Subdivision Comments

Date: 12/20/23

RE: SP-23-00012 KD Properties

KD PROPERTIES SHORT PLAT

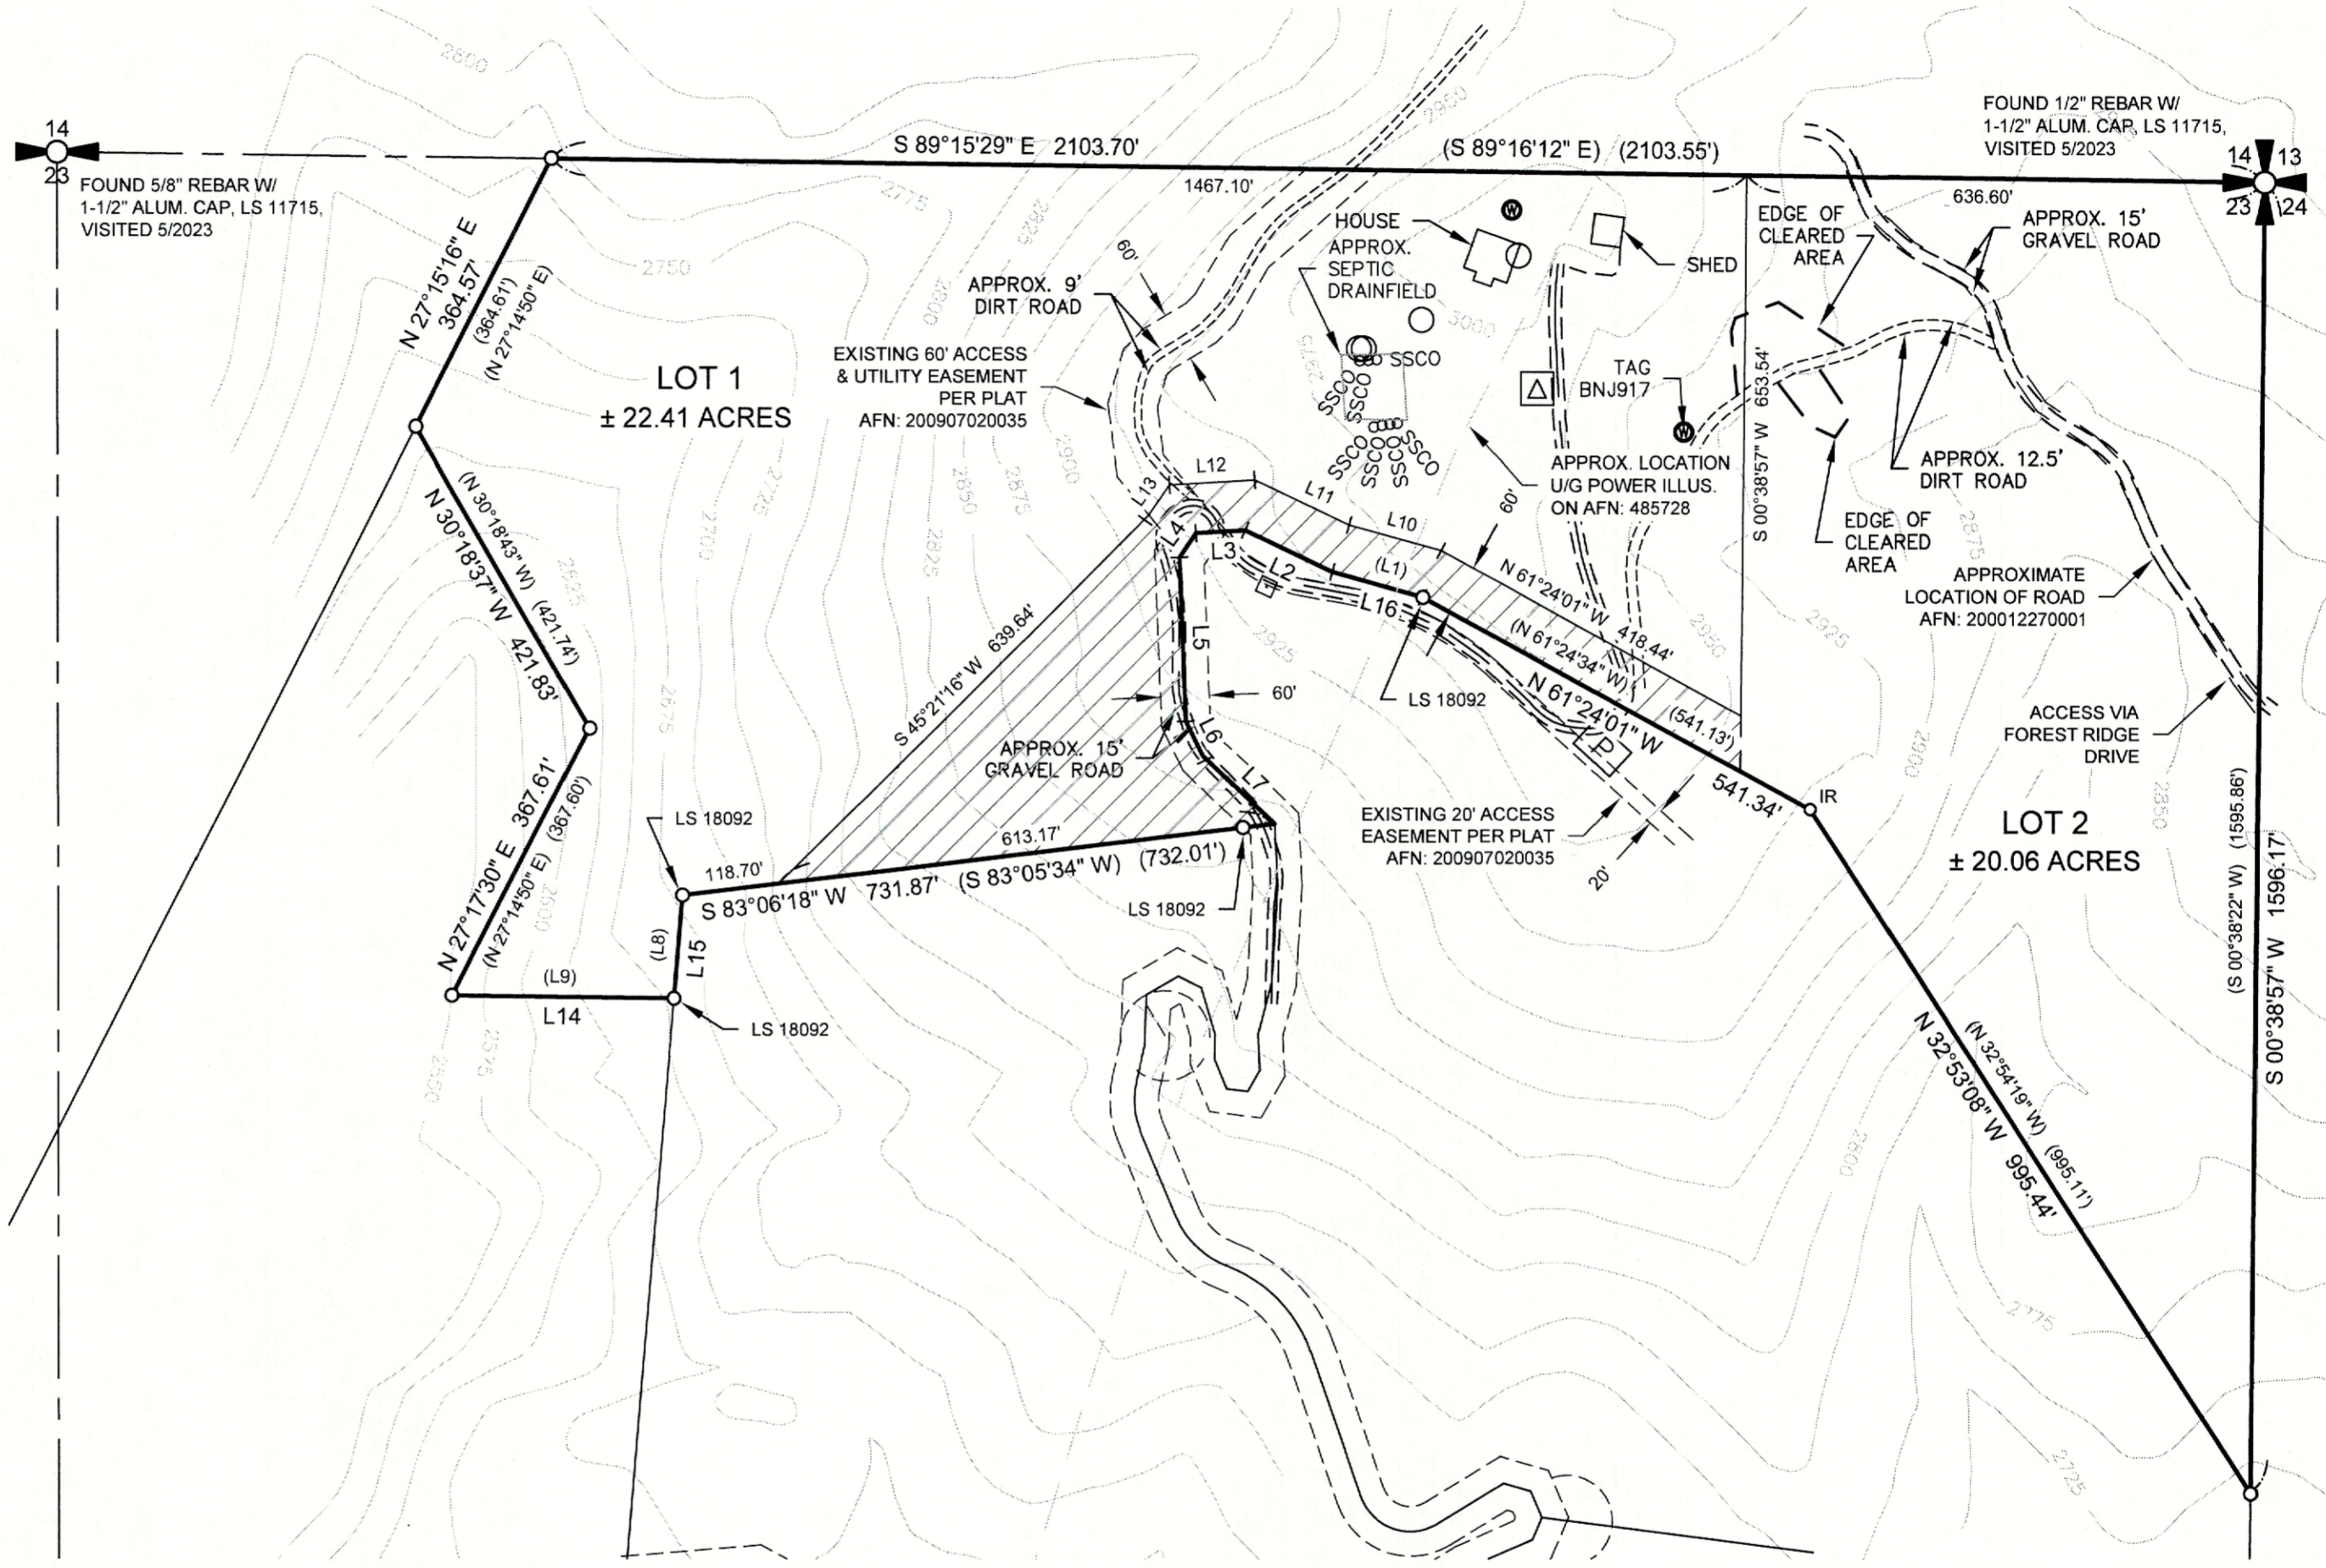
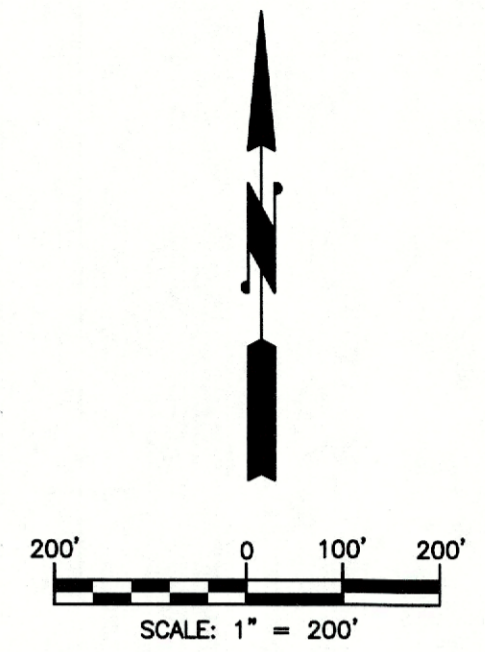
The proposed short plat drawing indicates there is an existing well on proposed lot 1. The applicant indicates there will be an individual or shared well on each lot. The applicant must prove legal and physical availability of water for all new uses of water on proposed lots.

A well log for the existing well on lot 1 (BNJ917) was downloaded from the DOE website and indicates a flow of $\frac{3}{4}$ of a gallon per minute. A new well is required to be drilled with a well log submitted for the proposed lot 2 unless the applicant intends to share the well. If this is the case, a signed, notarized and filed shared water user's agreement must be submitted for review. Additionally, a storage tank will be required for the proposed, shared water system as the flow is inadequate for 2 residences.
